REPORT UPDATE

Application No: BE/23/14/PL

Location: Adjacent Warehouse site to McDonalds Oldlands Way, Bersted

Description: Change of use from Class B8 (Storage or Distribution) to Class A1 (Shops) including partial demolition

Site Plan as Proposed

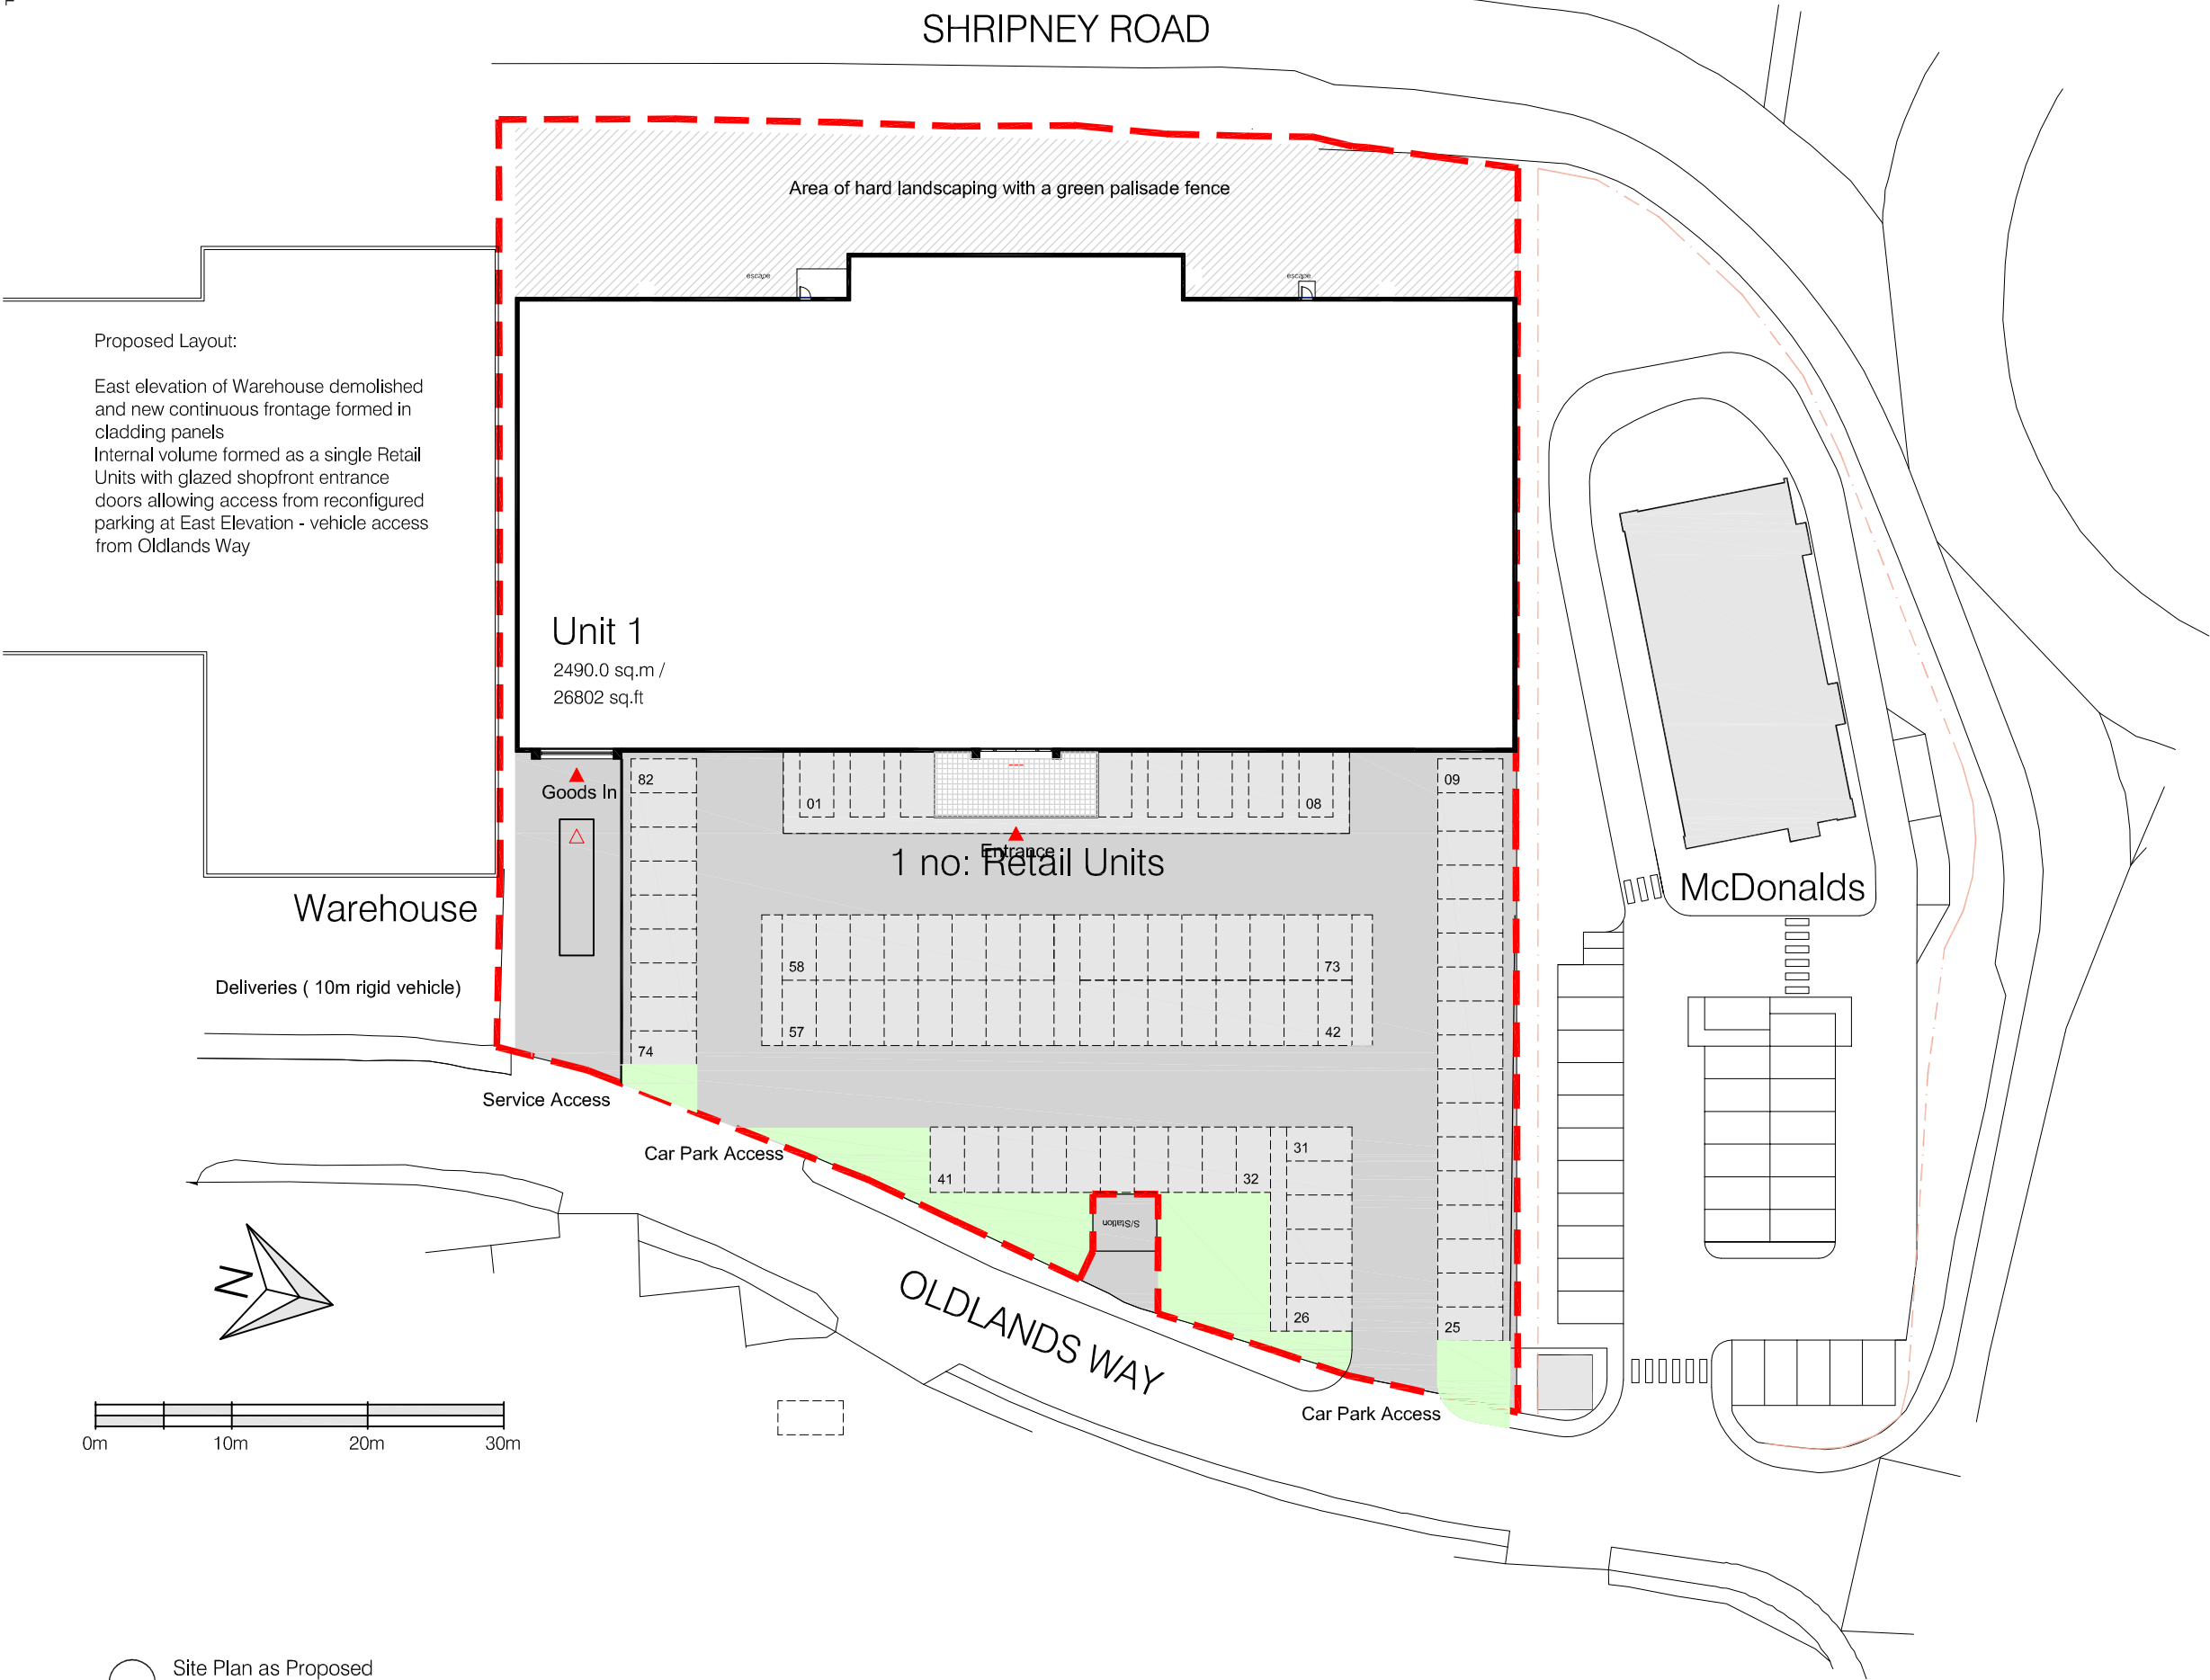
(2) In respect of proposed condition 07, the applicant pointed out that the submitted plans show that delivery vehicles will reverse into/out of the site. Therefore, it has been agreed with WSCC Highways that the condition be amended to make it clear that the turning facilities are only in respect of passenger vehicles. The condition is amended by the insertion of the word passenger as per the following:

The retail store shall not be occupied unless and until space has been laid out within the site in accordance with drawing Ref 593-PL(00)013 Rev B (01/10/14) for the parking of customer cars, staff cars, disabled vehicles & bicycles, for the loading & unloading of delivery vehicles and for passenger vehicles to turn so that they may enter and leave the site in forward gear. The approved parking and turning areas shall thereafter be retained for the approved use.
